A46 Newark Bypass

Scheme Number: TR010065

Statement of Common Ground with Nottinghamshire County Council

October 2024

Photomontage 25: Year 15 in operation (planar projection, field of view 39.6 degrees x 27 degrees, to be viewed at A3)

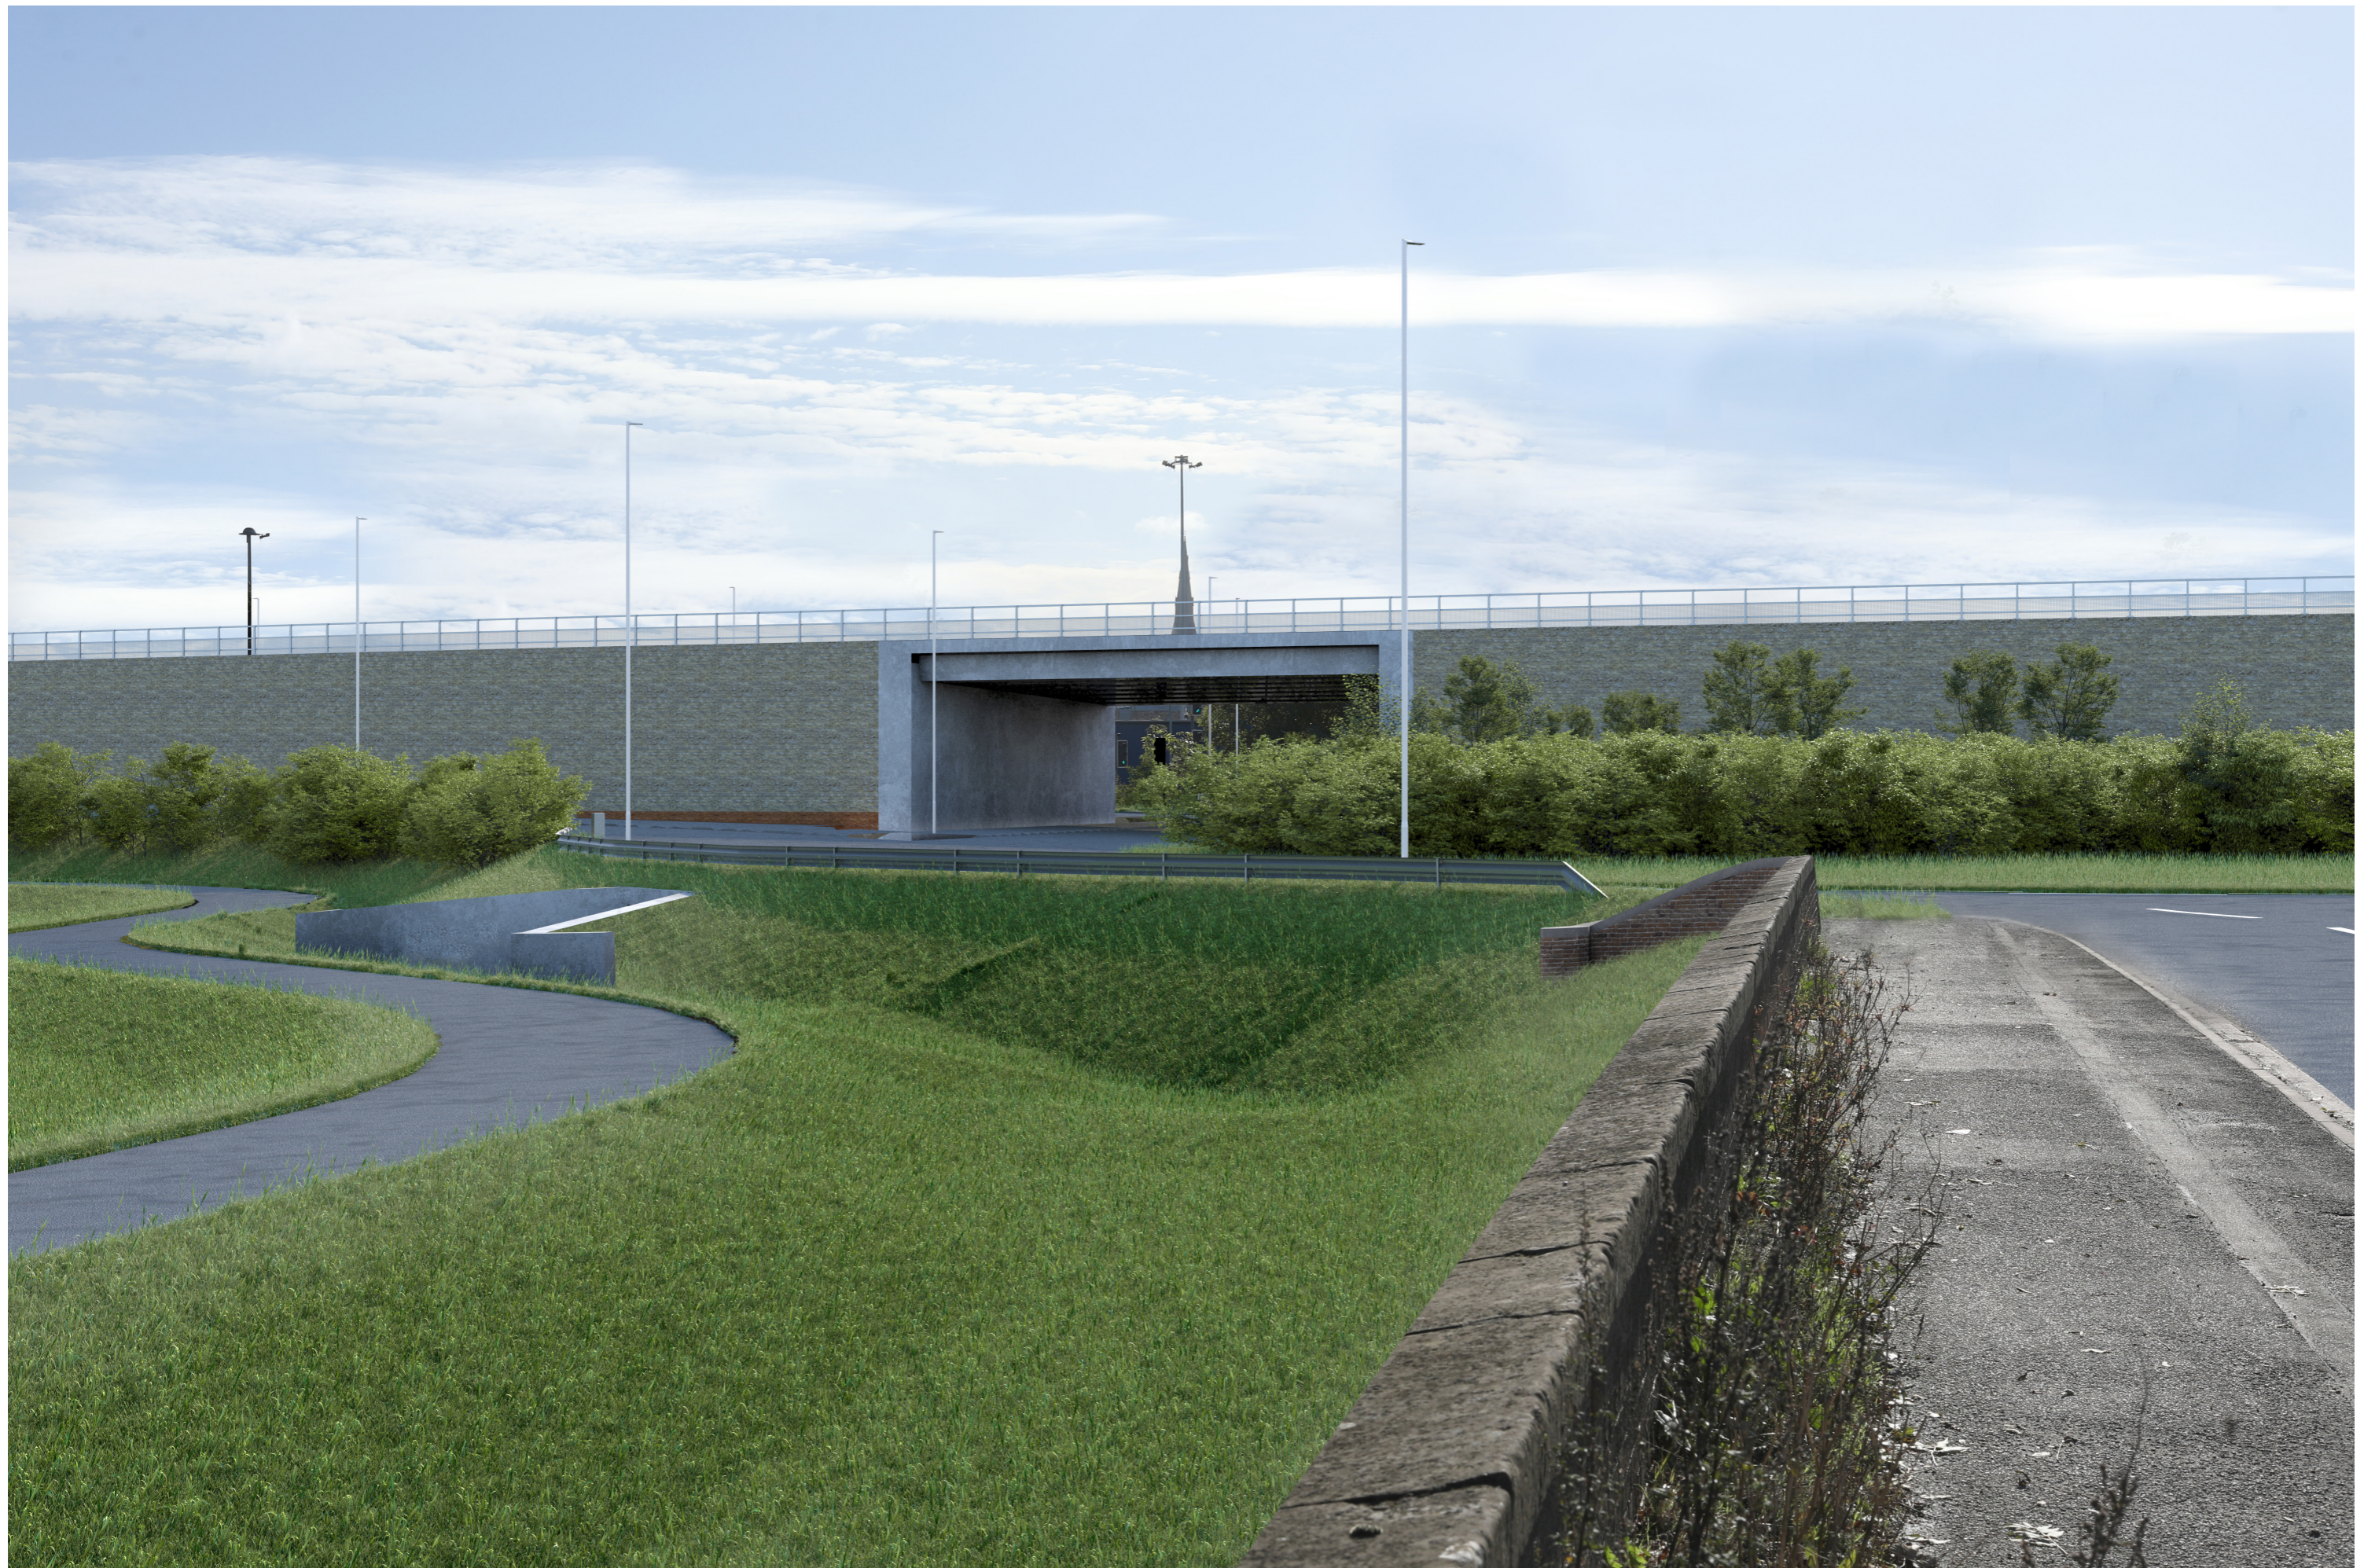
21.	Ecology (biodiversity)		<p><u>Attenuation pond locations</u></p> <p>The Scheme will inevitably lead to the loss of Local Wildlife Site habitat contained within the Great North Road Grasslands LWS 2/778 at the Cattle</p>	<p>Re-locating the basins outside of the Local Wildlife Site would require direct run-off against the natural fall of the land as well as the highway, which in turn would lead to piped runs</p>	Under Discussion	18/10/2024
